MEMORANDUM

DATE: January 29, 2024

SUBJECT: SP-20-005 – Eagle Rising  
Sixth Submittal (2022-2024 fifth review)

EAGLE WING DRIVE (PUBLIC) & EAGLE WING VIEW (PRIVATE)
 STA 1+54.66 TO 3+35.96 & STA 3+35.96 TO 11+92.62

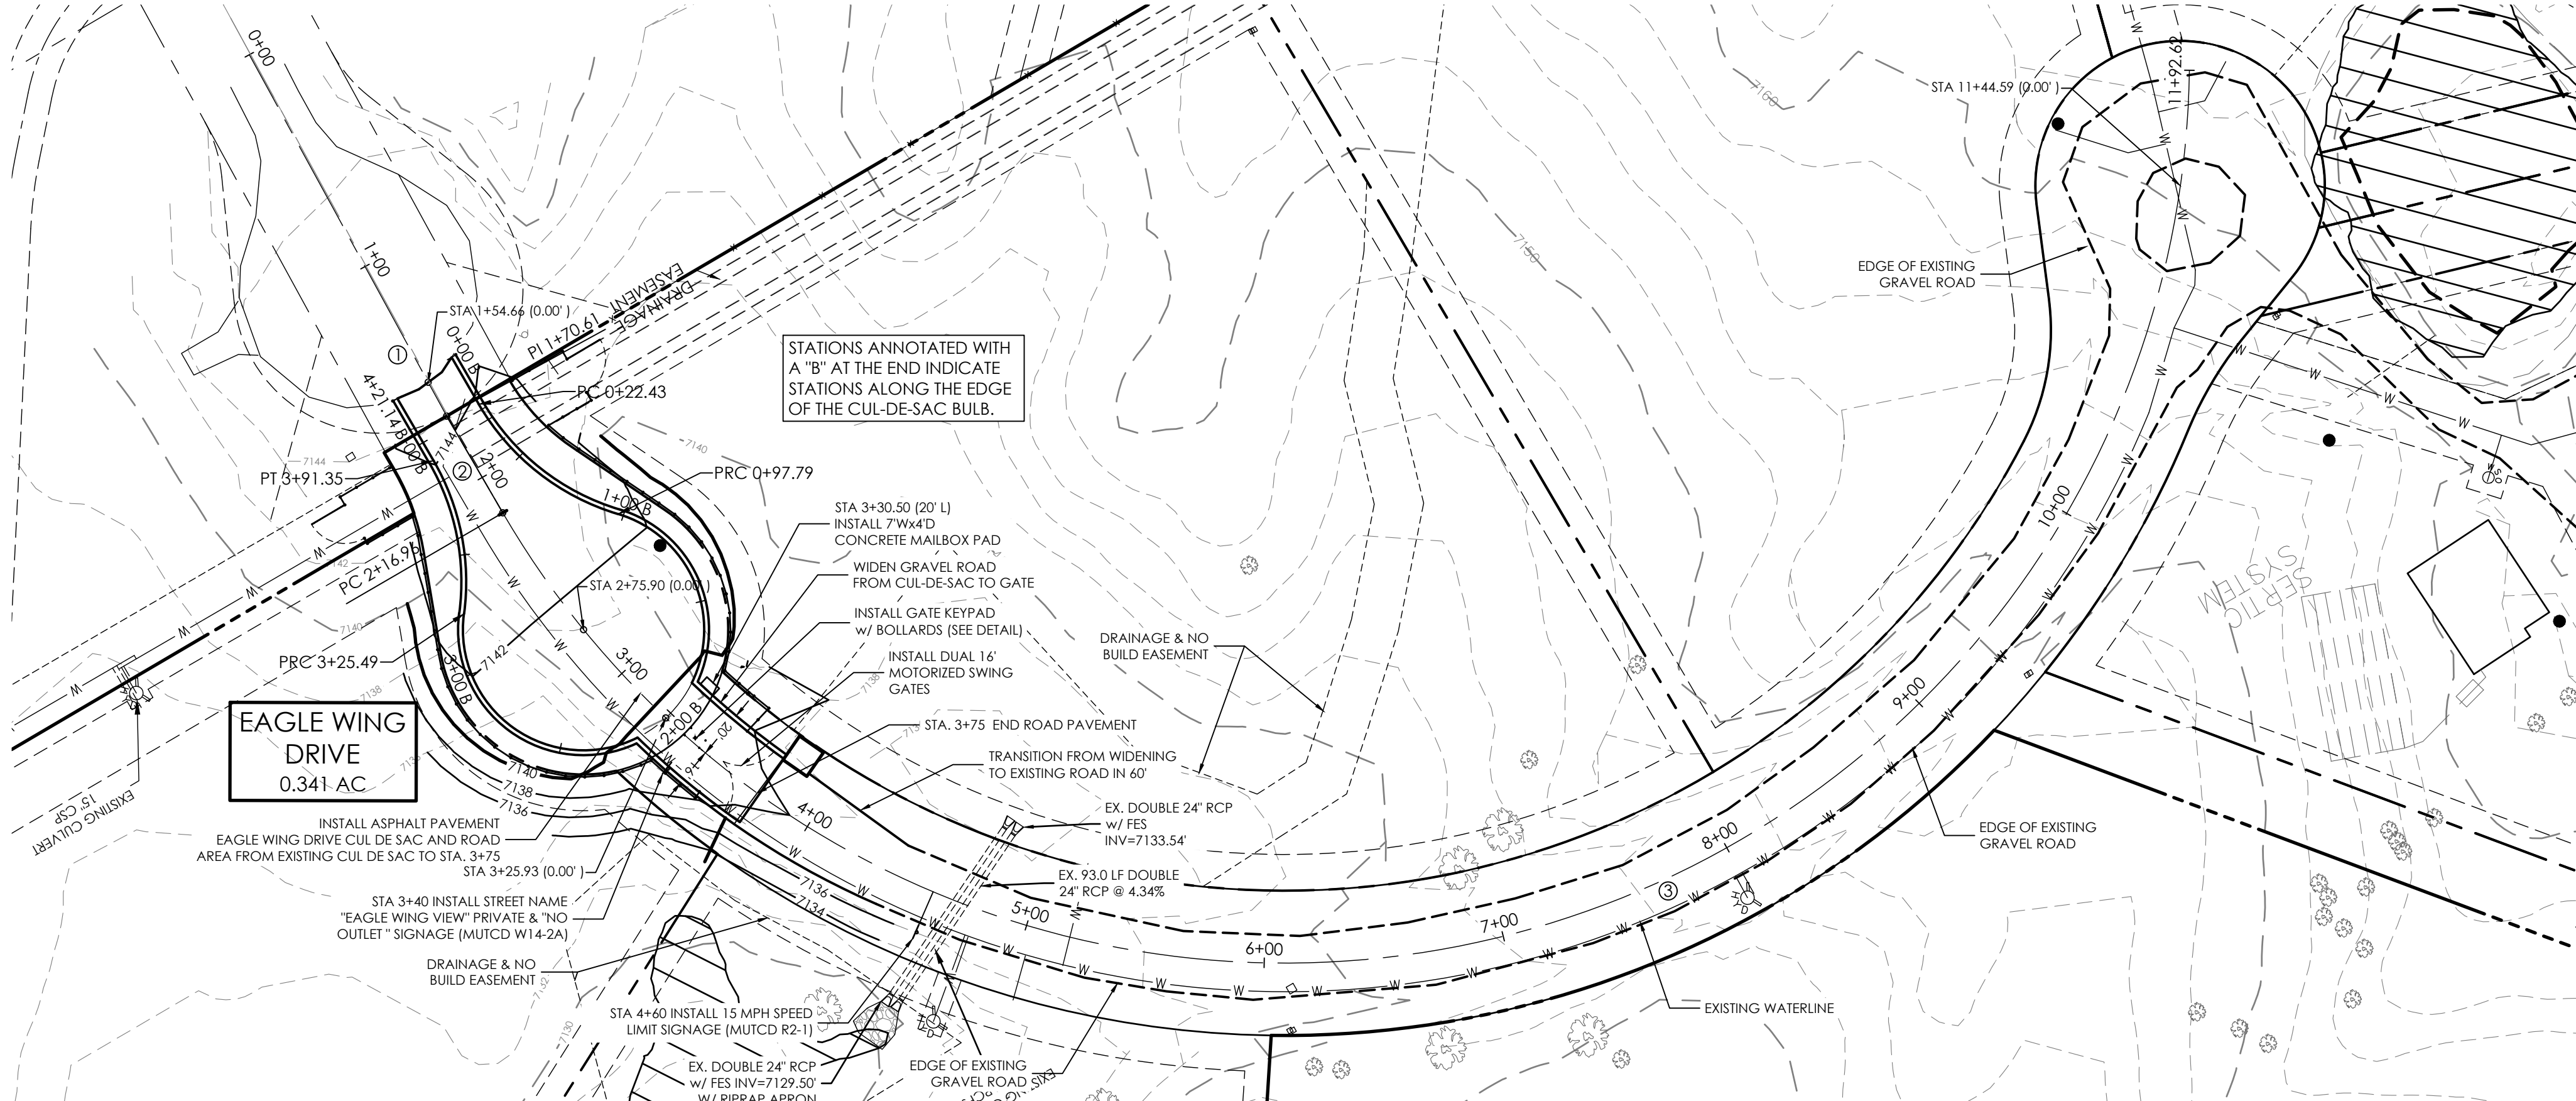
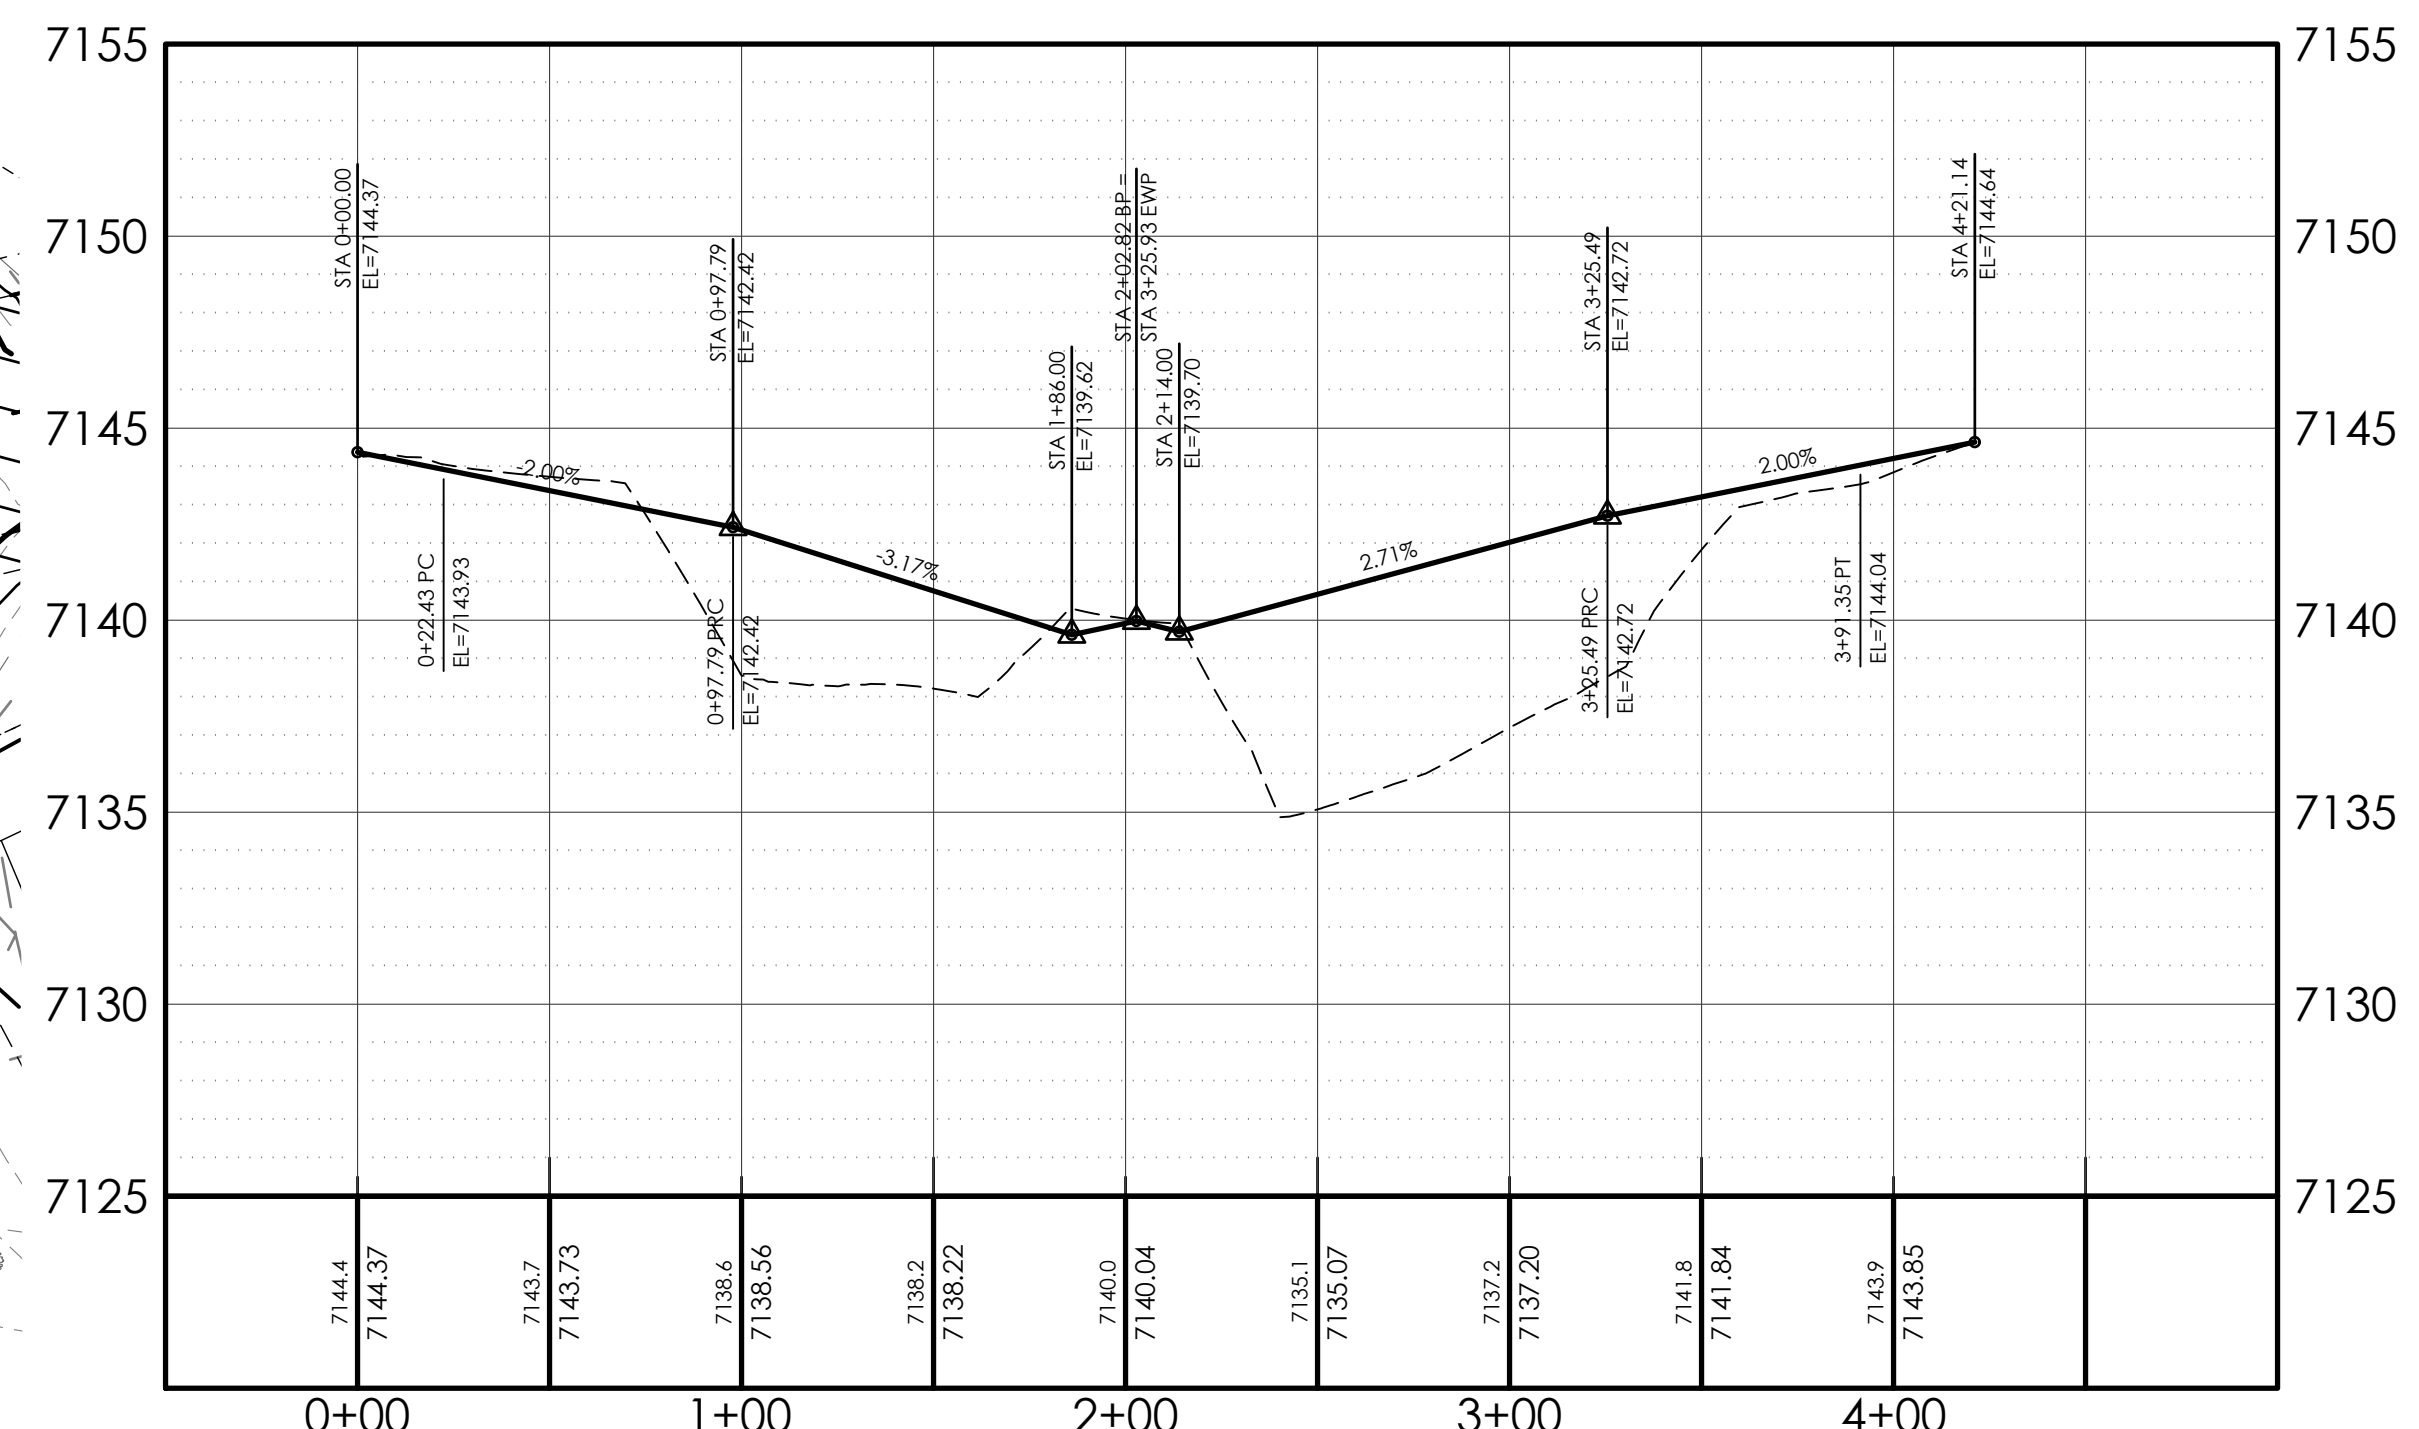
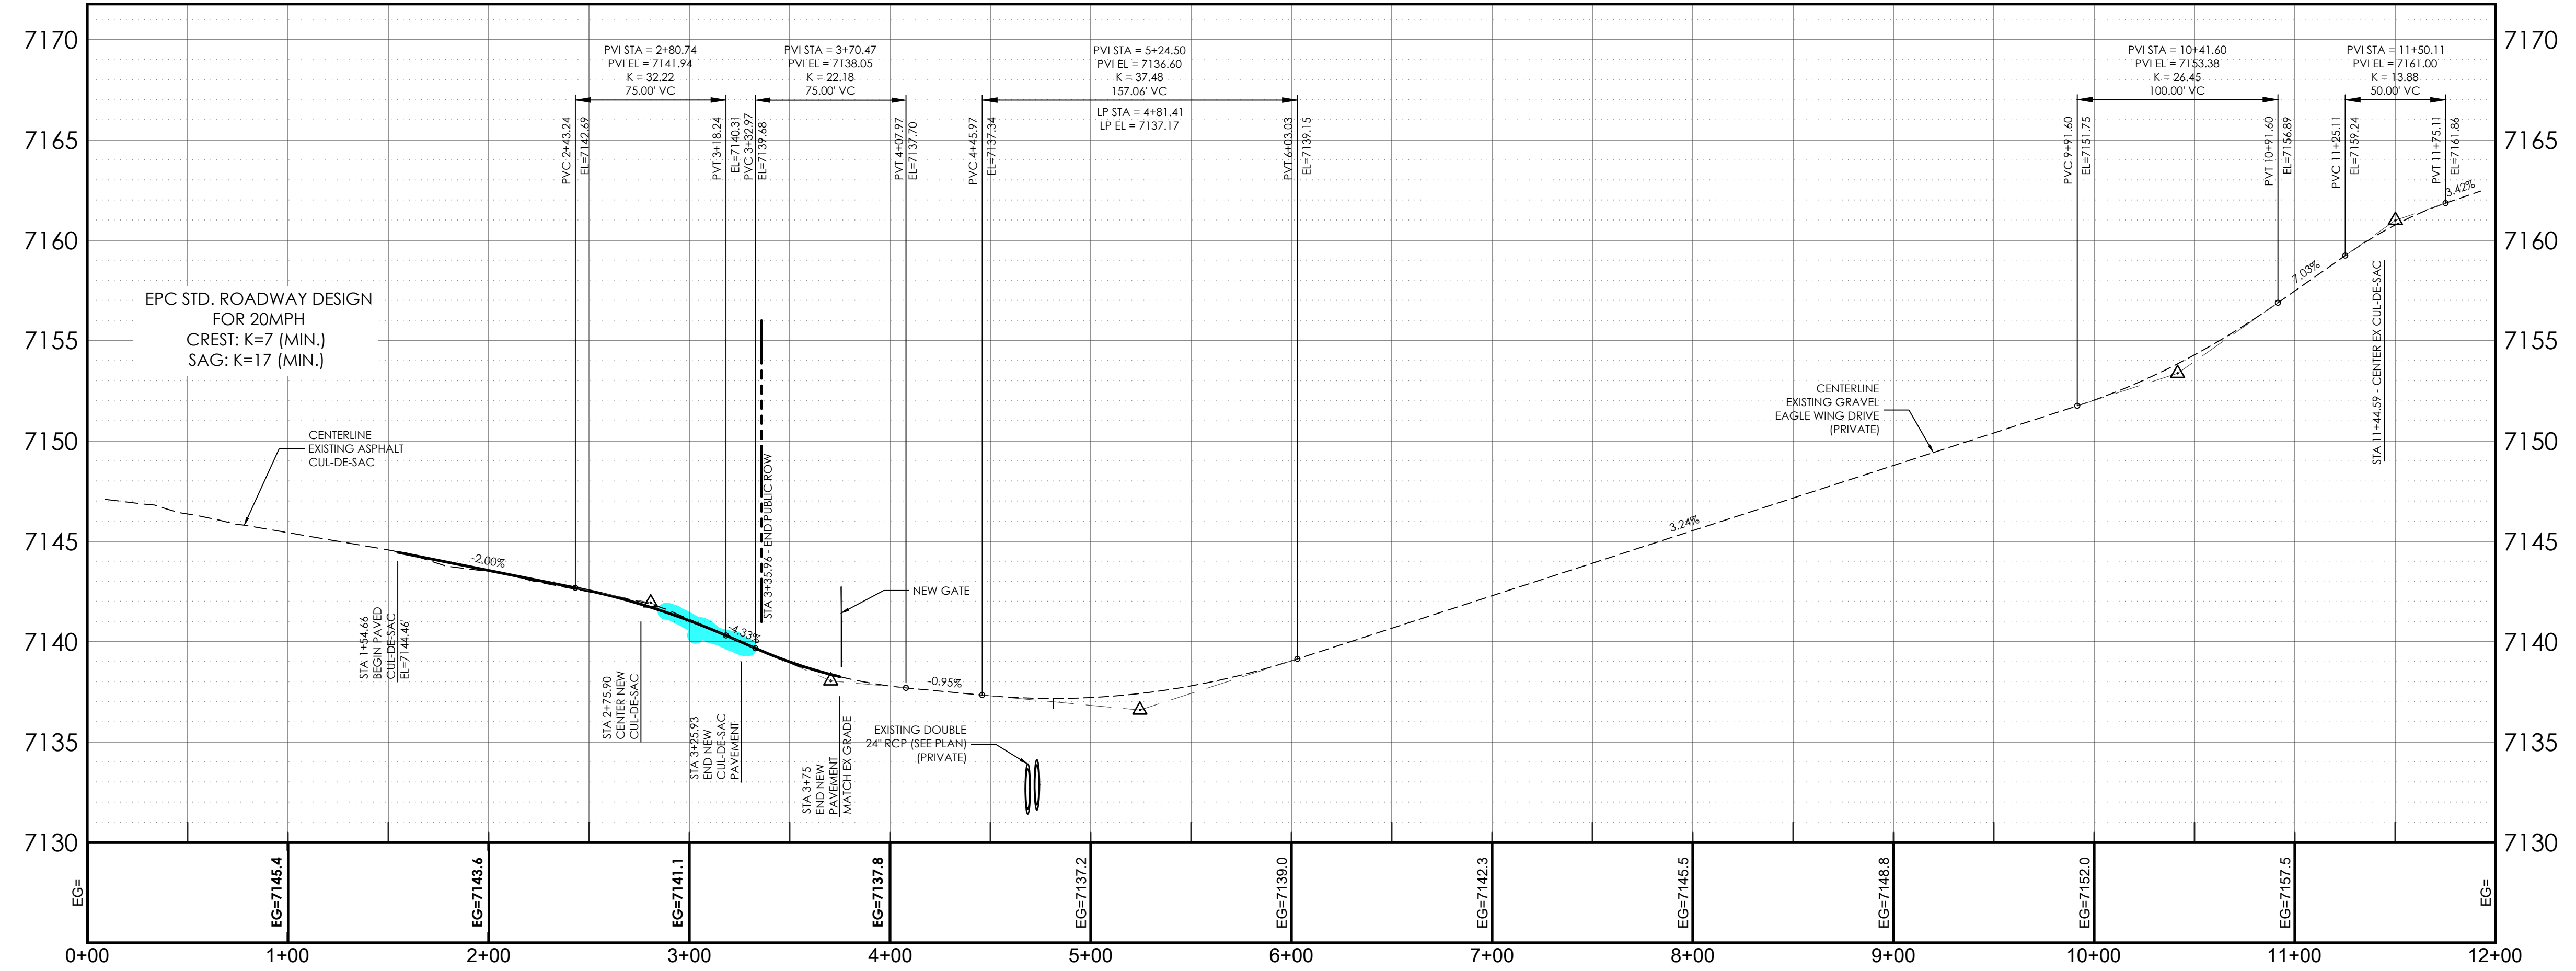
2. Provide deviation requests as needed. *Partially resolved; provide referenced cross-section exhibit with the deviation request.* Unresolved; see fire district comments. *Partially resolved; see updated deviation request redlines.* **RESPONSE:** Comment is addressed in the Cul-de-sac length Deviation Request as discussed in the February 29 meeting and reviewed and confirmed complete/accepted by Jeff Rice in the March 7, 2024 meeting.

- a. *Minor redlines on cul-de-sac length request, add map.* **RESPONSE:** Comment is addressed in the Cul-de-sac length Deviation Request as discussed in the February 29 meeting and confirmed complete/accepted by Jeff Rice in the March 7, 2024 meeting.

- b. *Due to a recent change in policy regarding private roads, revise the road design deviation request to only include deviations for the public road segment and cul-de-sac. This deviation request can then be resubmitted with the final plat if desired.* **RESPONSE:** This comment was rescinded by county staff. Comments to the Roadway Cross Section Deviation were addressed in the revised document as discussed in the February 29 meeting and confirmed complete/accepted by Jeff Rice in the March 7, 2024 meeting.
